Please ask for: Mrs D Johnson
Email: daun.johnson@arun.gov.uk
Telephone: 01903 737762
Our Ref: BE/63/20/HH
Your Ref:
Date: 6th July 2020

Application for Planning Permission for Works or Extension to a Dwelling

Development: Conversion of garage to one bed annex with single storey extension.
Location: 414 Chichester Road Bersted PO21 5DR

GROUND FLOOR PLAN
[As Proposed]

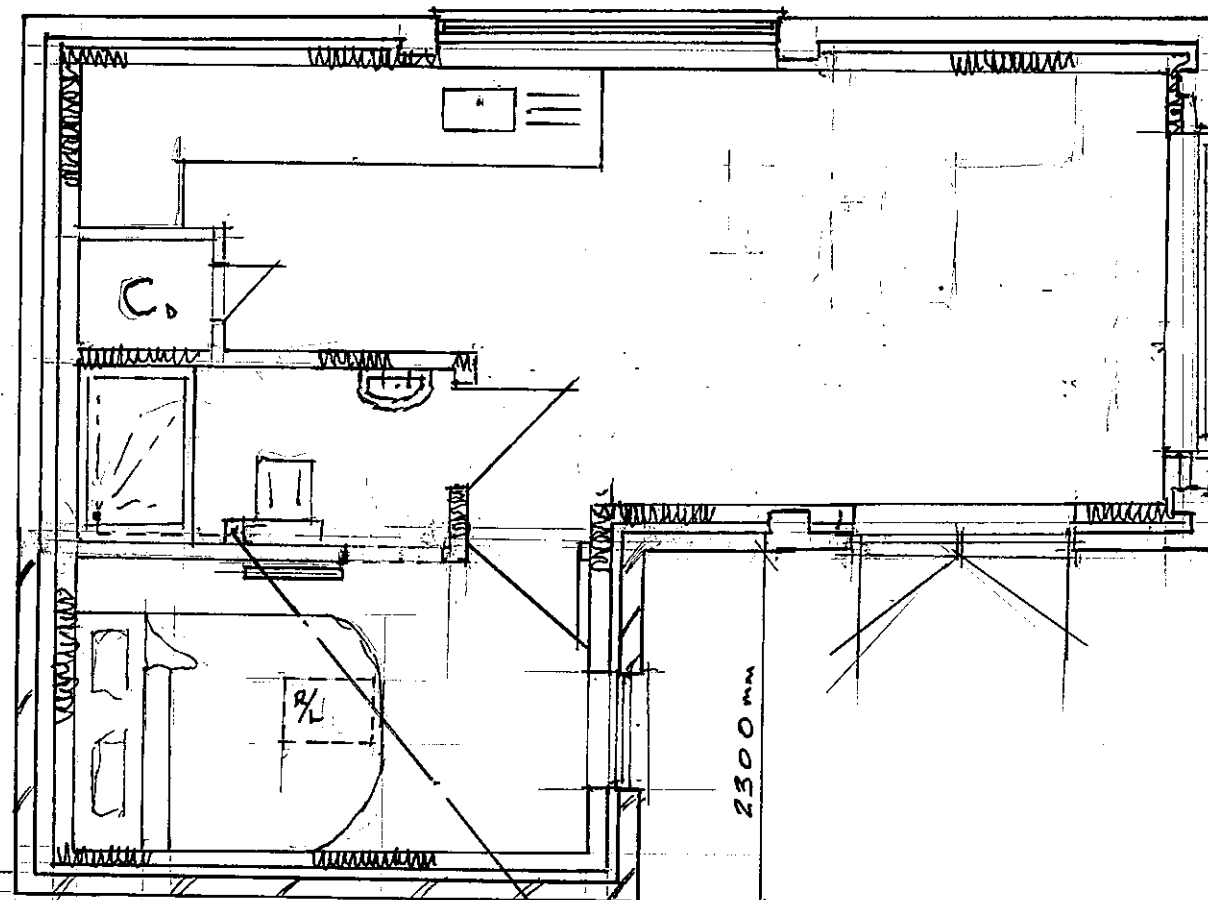
Please clearly show all roof lights on the proposed floor plan and proposed elevations (on roof).
